Final Report - Corrections Required **Application No. DEPN-24-0160**

Description : Multi-family development with 170 rental duplex units on one development lot. Also a request for alternate landscape compliance related to placement of streamside overly and property boundary buffer plantings, and to be allowed to provide 9.4% active open space where 10% is required.

Address : 2210 Old Ranch RD Colorado Springs CO 80920

Document Filename : Cottages at Kettle Creek DP_1st_Submittal_101524.pdf

## SITE PLAN

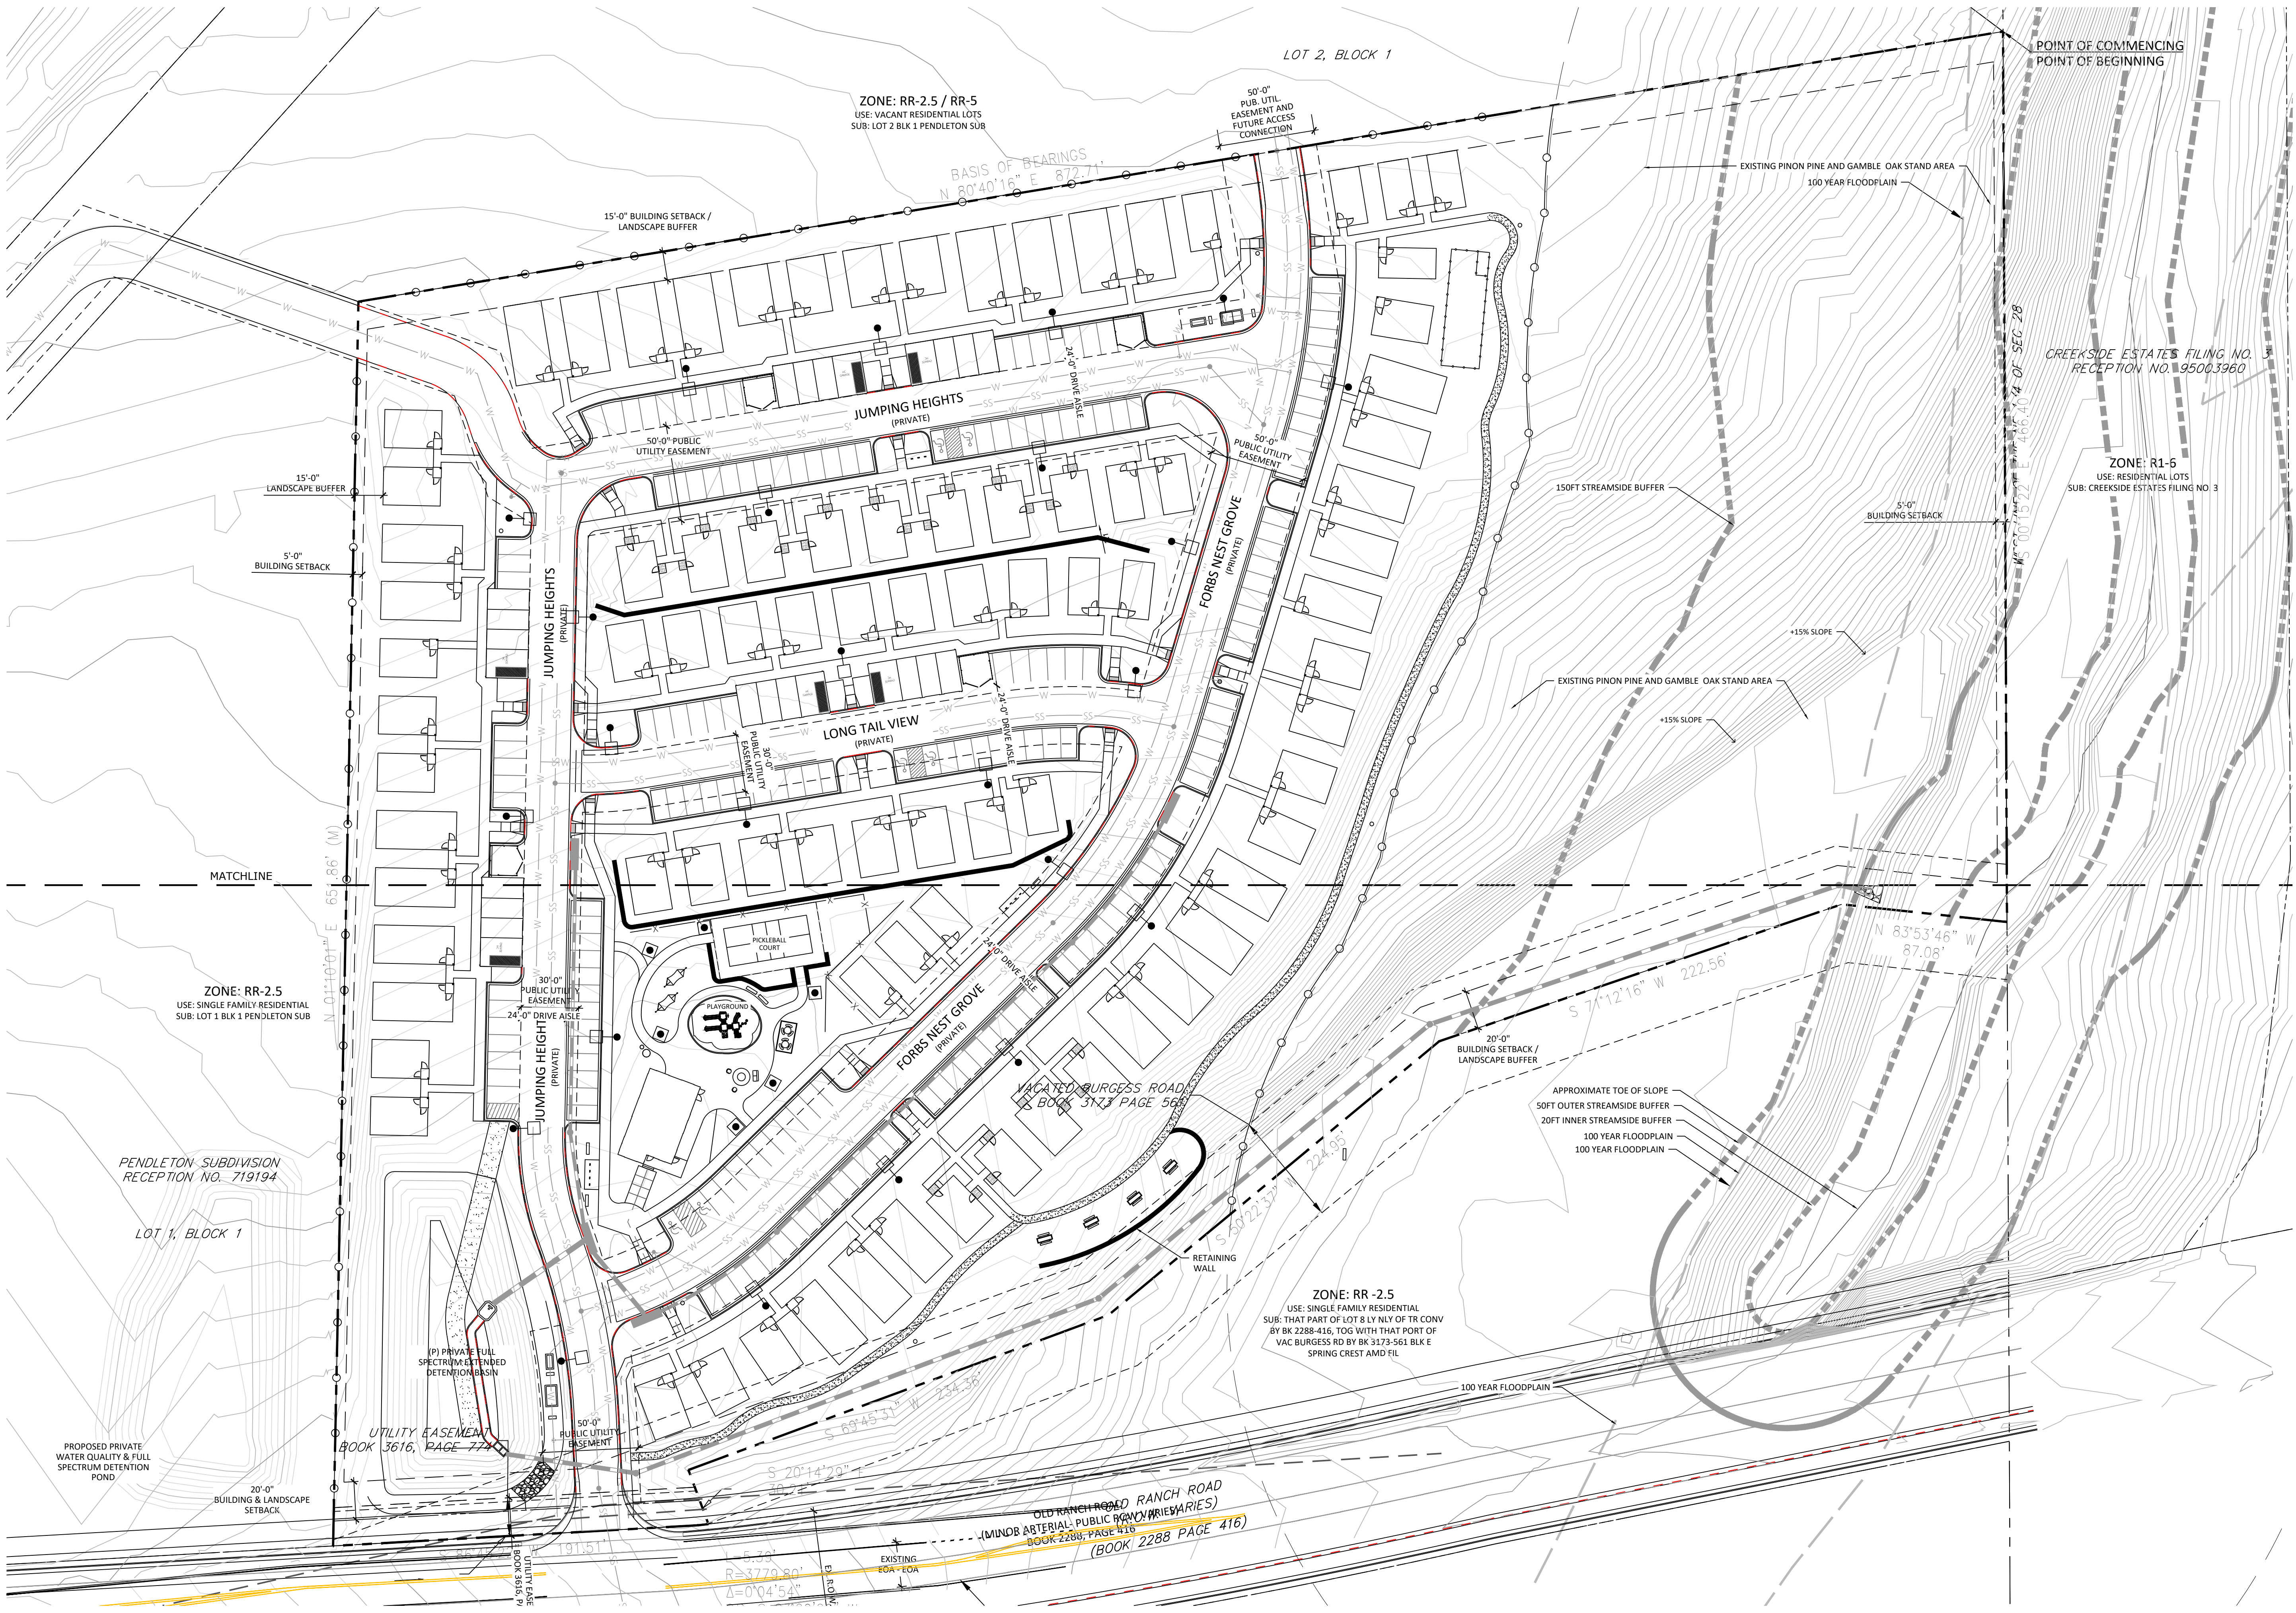
Comment ID	Page Reference	Reviewer : Department	Review Comments
15	2	Zaker Alazzeh : City Eng - Traffic Engineering	<p>1- The developer shall dedicate approximately 13 feet of ROW and 5 feet easement along the southern lot side on Old Ranch Road.</p> <p>2- Please add the following note to the development plan: "The developer will be required to construct an eastbound left turn lane at Old Ranch Road and the proposed site access intersection. This turn lane will need to contain 155 feet turn lane and 160 feet long transition taper."</p> <p>3- The details of the signing and striping of the future public roadway improvements will be addressed during the construction plans review.</p>
54	1	Jonathan Scherer : City Engineering - SWENT	Include the Plat title in the title or cover sheet of the Development Plan.
55	1	Jonathan Scherer : City Engineering - SWENT	DEPN-24-0160
56	2	Jonathan Scherer : City Engineering - SWENT	Green Infrastructure: the Planned Infiltration Area (PIAs) need to be delineated with a line or a hatch. There must be a leader calling it out as a "Planned Infiltration Area" or it must be included in the legend as "Planned Infiltration Area.". This must match what is being shown in the PDR/FDR. The PIAs should be shown on the Landscape Plans, Grading Plans, and Utility Plans. Please see the revised Development Plan checklist for further clarification: https://coloradosprings.gov/system/files/2023-06/development_plan_checklist.pdf

80	1	Austin Cooper : Planning	provide plan number that you are changing
81	1	Austin Cooper : Planning	show guest parking calculations
24	2	Caroline Miller : Planning	Confirm adjacency, by City GIS, City owned Open Space is adjacent to this site.

DESIGN: NQJ  
REVIEW: REB  
DATE: 10/15/2024  
H-SCALE: 1" = 30'  
V-SCALE: N/A  
SHEET  
3 OF 24

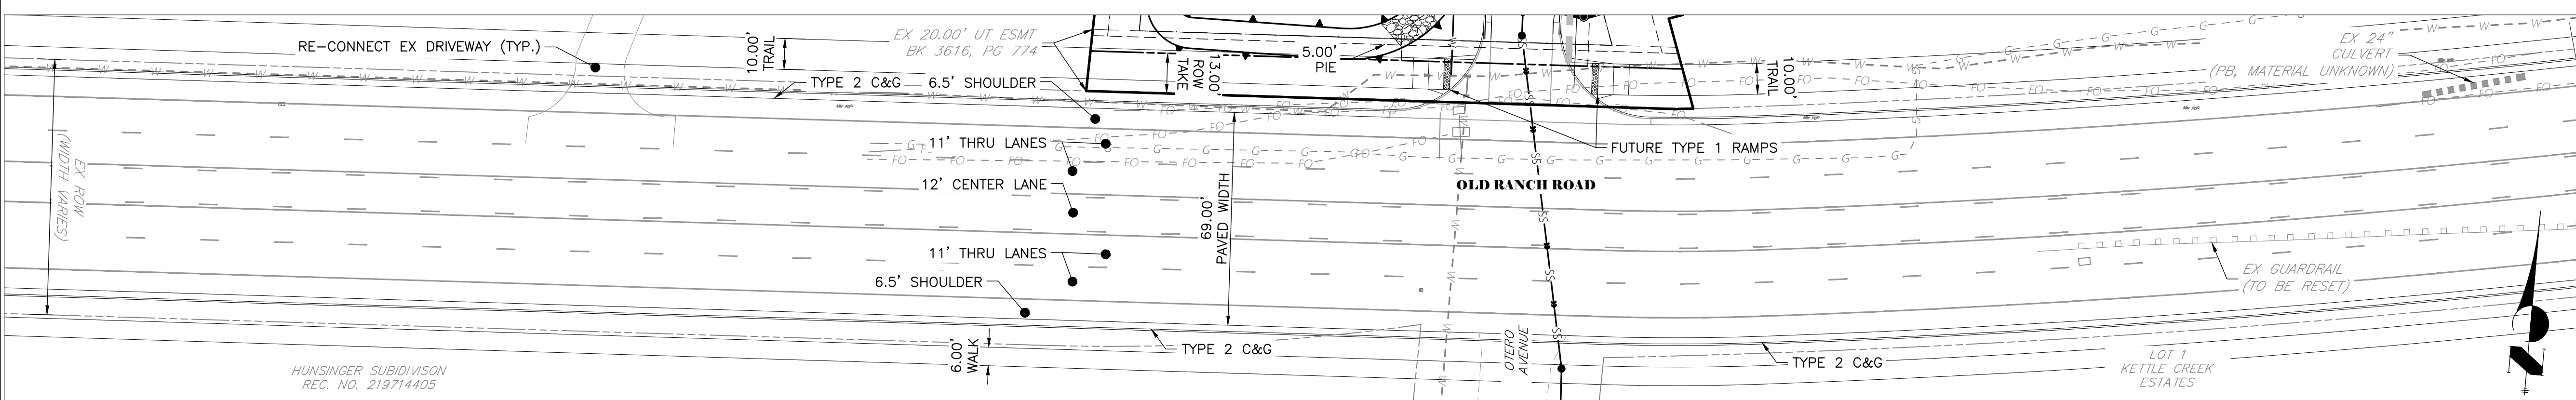
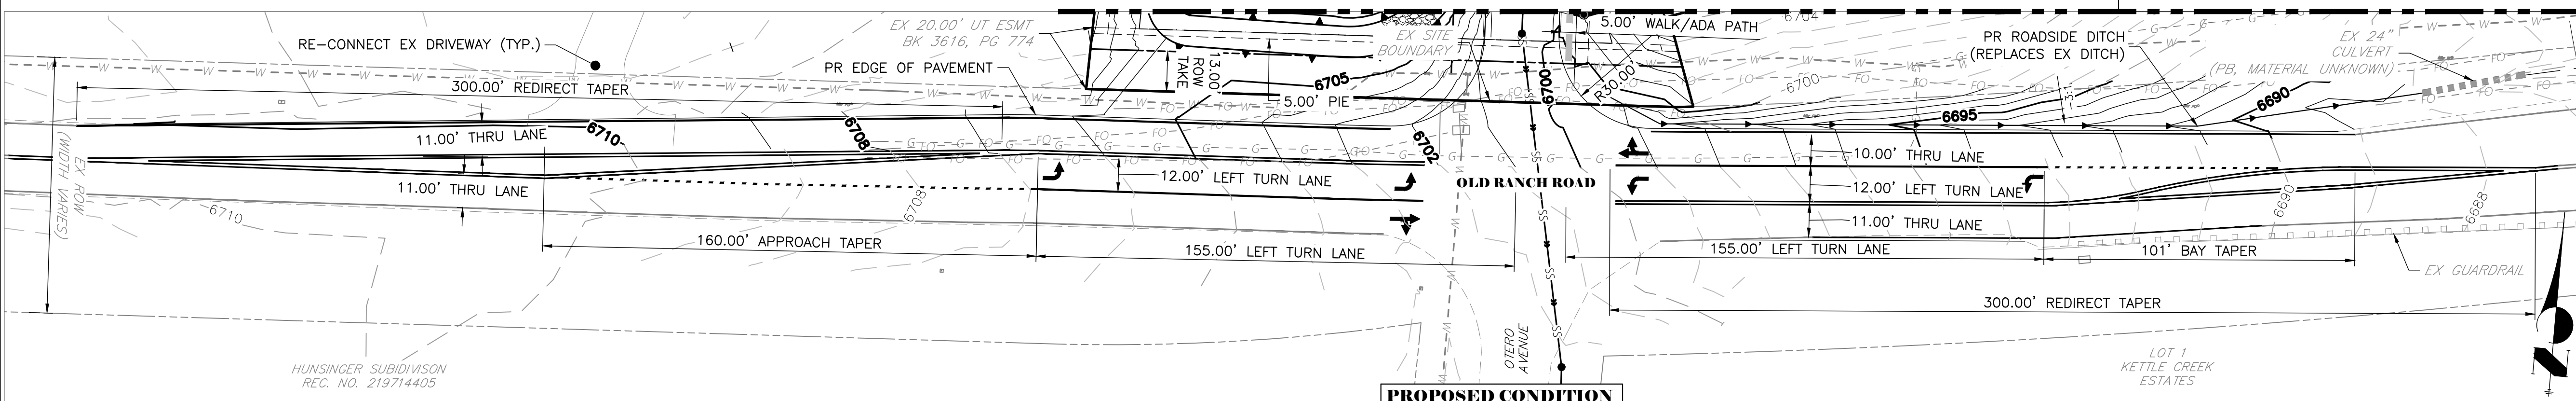
59	3	Jonathan Scherer : City Engineering - SWENT	The access road must be included in the total disturbed area in the PDR.

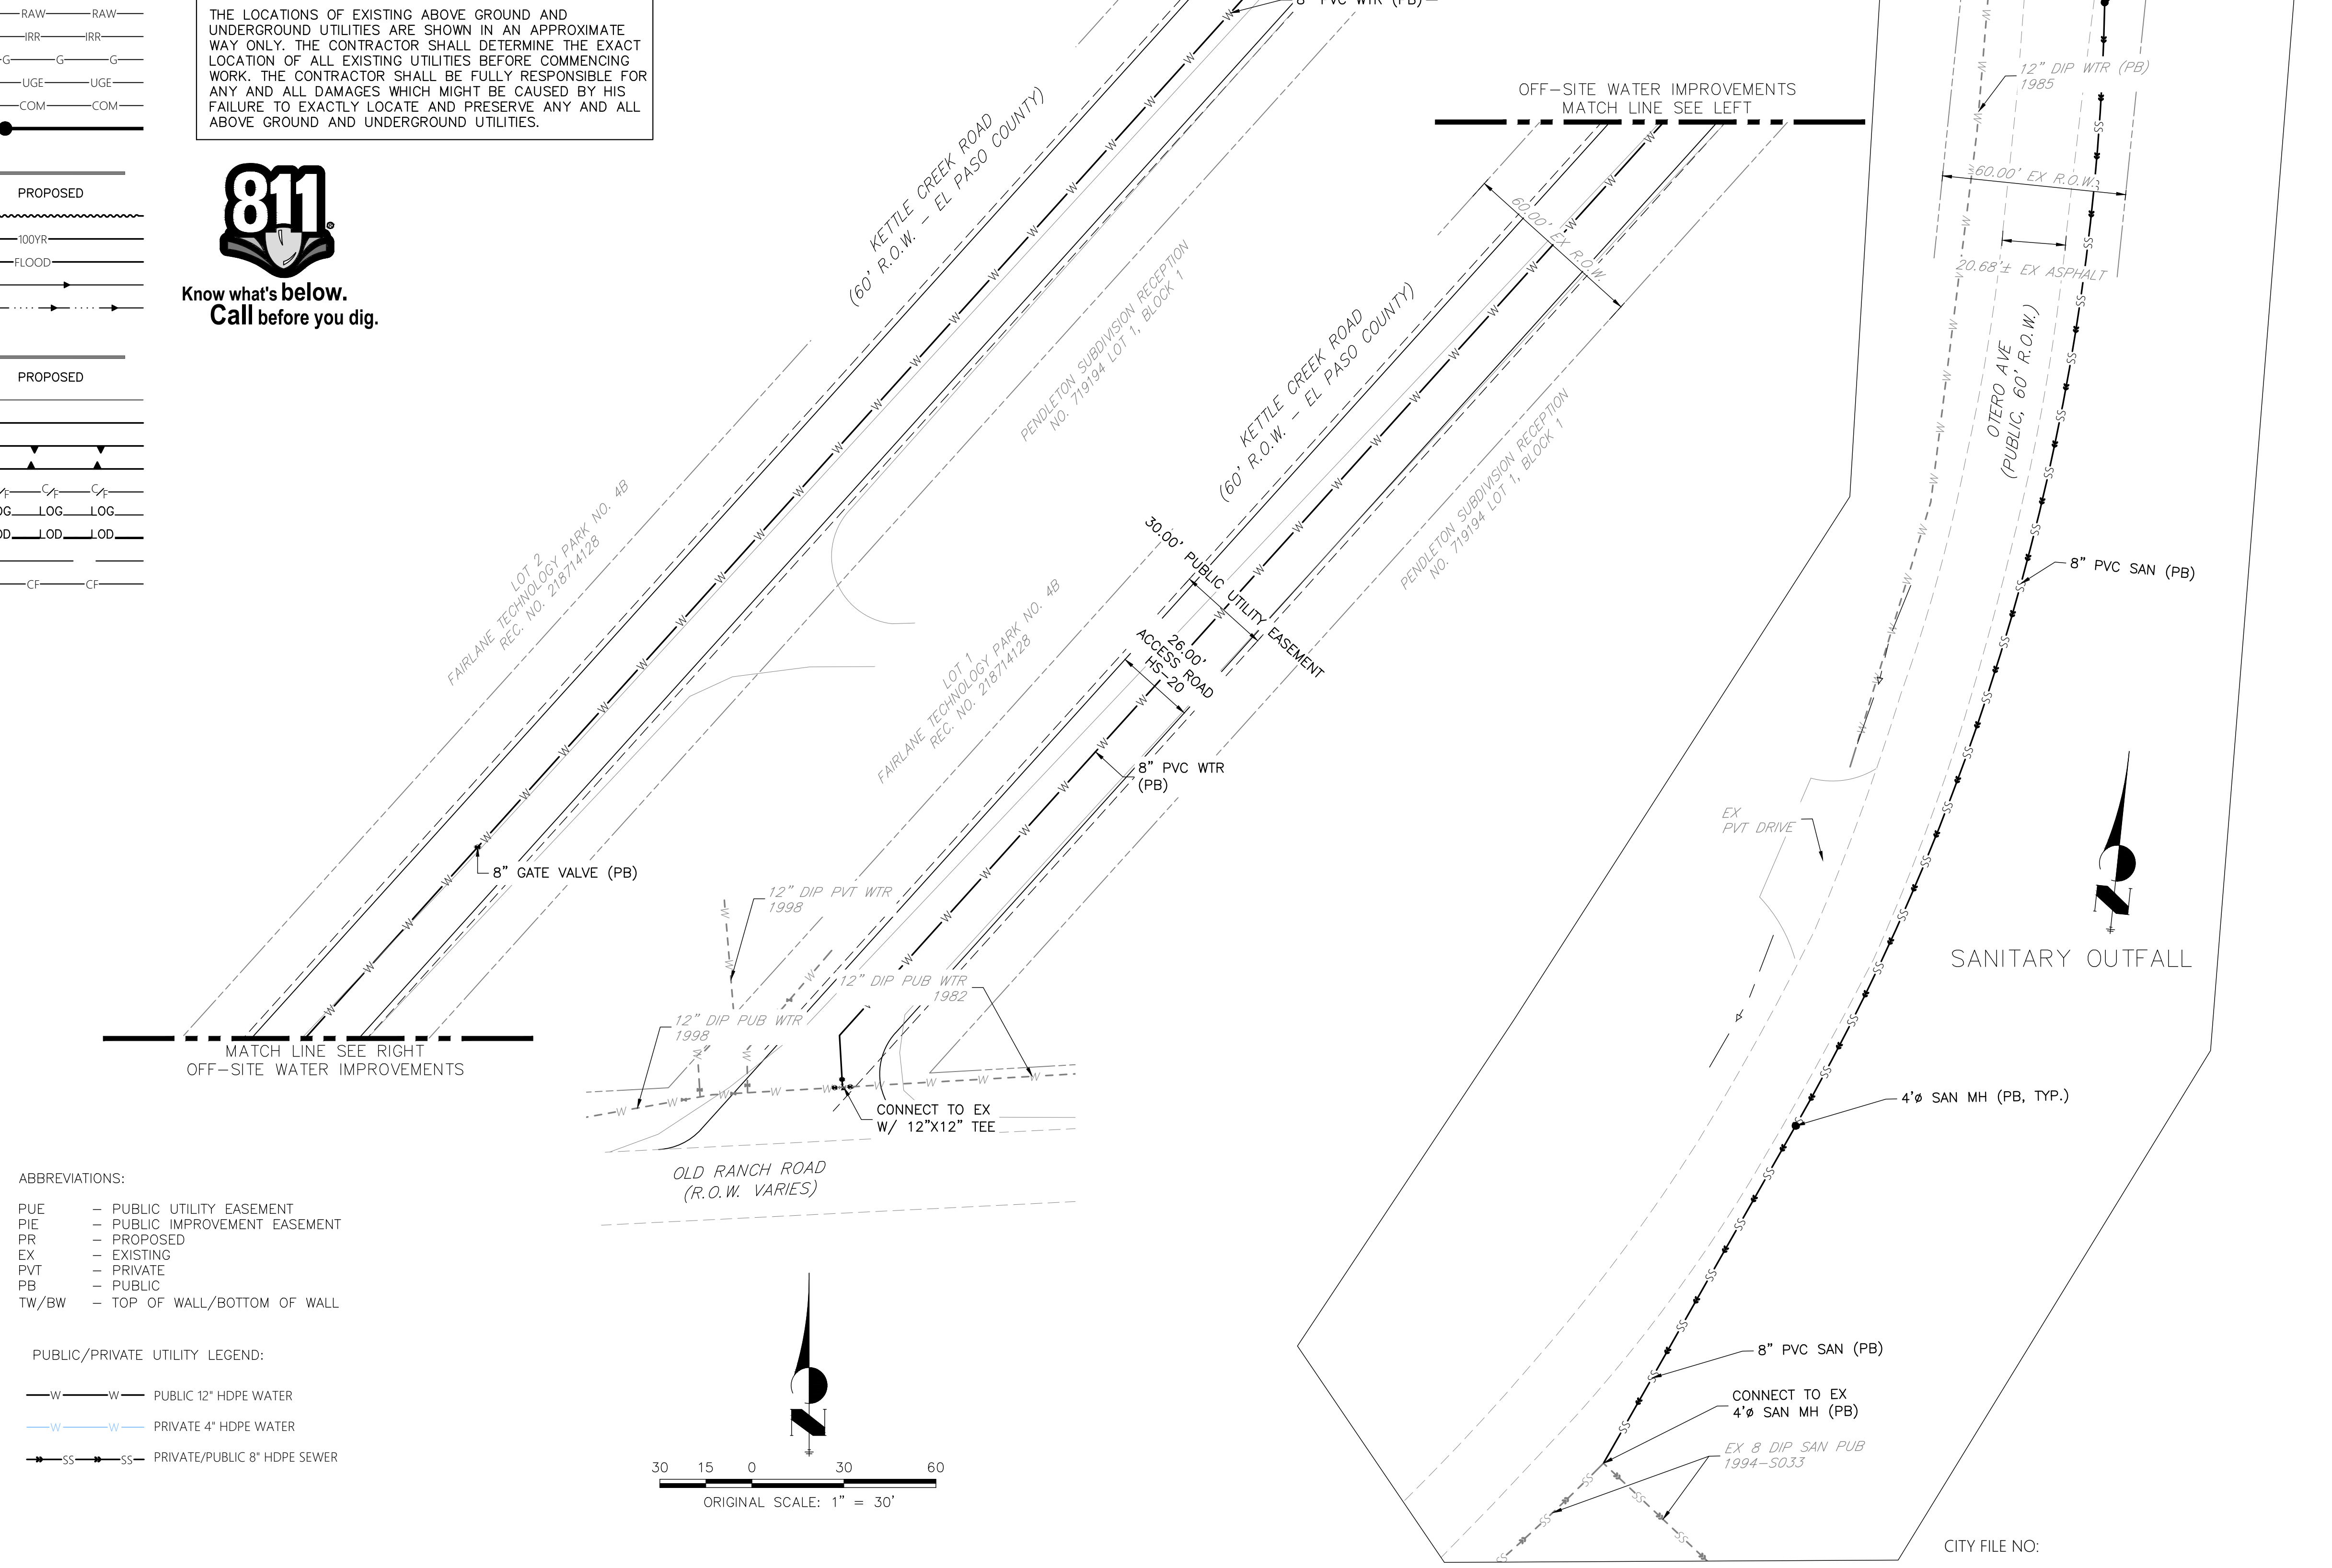
Comment ID	Page Reference	Reviewer : Department	Review Comments
60	4	Jonathan Scherer : City Engineering - SWENT	Info Only: It appears there is runoff from disturbed area flowing offsite without being treated. Please note that no more than 5% of the total area of disturbance (totaling no more than 1 acre) shall flow offsite without receiving WQ treatment.
61	4	Jonathan Scherer : City Engineering - SWENT	The invert of the outfall pipe must be set to 1-2 feet above the flowline of the channel.
62	4	Jonathan Scherer : City Engineering - SWENT	Info Only: The erosion protection of the outfall must be modeled in the FDR to show stability in the 100-year channel flow event.
63	5	Jonathan Scherer : City Engineering - SWENT	None of the utilities are labeled as PR or EX, please clarify what is being proposed.
64	5	Jonathan Scherer : City Engineering - SWENT	All swale, detention basin, and proposed storm infrastructure calculations must be included in the PDR.

65	5	Jonathan Scherer : City Engineering - SWENT	Adjust leaders and callouts so all components of the pond can be reviewed.
66	5	Jonathan Scherer : City Engineering - SWENT	Erosion protection for the spillway must be shown to a stabilized surface (I.e. back of curb).
67	5	Jonathan Scherer : City Engineering - SWENT	All areas associated with the installation on the outfall pipe must be included in the total disturbed area in the PDR.
68	9	Jonathan Scherer : City Engineering - SWENT	Please show and label all private and public easements as applicable on all sheets.
69	9	Jonathan Scherer : City Engineering - SWENT	Ensure this matches the plans.
71	1	Joel Dagnillo : City Engineering Dev Review	Please revise the previous geological hazard validation letter for this development (previously approved 4-30-24 with #DEPN-23-01086) to reflect the updated project layout, and submit in Project Dox for City review/approval.

73	4	Joel Dagnillo : City Engineering Dev Review	Add a note stating that upon submittal of construction plans for turn lanes, an amount will be collected by the City for future ultimate installation of Type 1 Curb/Gutter, pedestrian ramps at access and 10' trail along property frontage to be installed with future PPRTA Project.
26	5	Matthew Alcuran : Col Springs Utilities	Action Item: Water service 4" & larger is considered main line. Label as such.
27	5	Matthew Alcuran : Col Springs Utilities	Action Item: Call out easement to include width.

Comment ID	Page Reference	Reviewer : Department	Review Comments
28	5	Matthew Alcuran : Col Springs Utilities	Action Item: Wastewater needs to be minimum of 5' from gutter. Provide dimension to confirm.
29	5	Matthew Alcuran : Col Springs Utilities	Action Item: Call out overall height of retaining wall. Provide section view to confirm.
30	5	Matthew Alcuran : Col Springs Utilities	Action Item: Please revise to ensure 10-foot horizontal separation between water and wastewater is provided or notate secondary containment where applicable.
31	5	Matthew Alcuran : Col Springs Utilities	Action Item: Please revise to ensure 10-foot horizontal separation between water and storm is provided or notate secondary containment where applicable, typical.
32	5	Matthew Alcuran : Col Springs Utilities	Action Item: Add note "A minimum of 3-foot clearance around the circumference of all fire hydrants will be kept clear of any physical or visual obstructions to the hydrant."

33	5	Matthew Alcuran : Col Springs Utilities	Action Item: Keep manhole placement center of drive lane.
34	5	Matthew Alcuran : Col Springs Utilities	Action Item: Add note "CSU Field Engineer to determine final gas/electric meter, transformer and service line locations. Contact Field Engineering at 719-668-4985 (Gas) or 719-668-5564 (Electric) with any questions."
35	5	Matthew Alcuran : Col Springs Utilities	Action Item: Gas and electric meter locations on plan view and building elevations must be shown and labeled.
36	5	Matthew Alcuran : Col Springs Utilities	Action Item: Please show and label any proposed EV chargers and upload Load Data.
37	5	Matthew Alcuran : Col Springs Utilities	Action Item: Add note "Fencing shall not stop access to utility lines or conflict with utility equipment."
38	5	Matthew Alcuran : Col Springs Utilities	CSU staff reserves the right to add new comments on subsequent submittals.
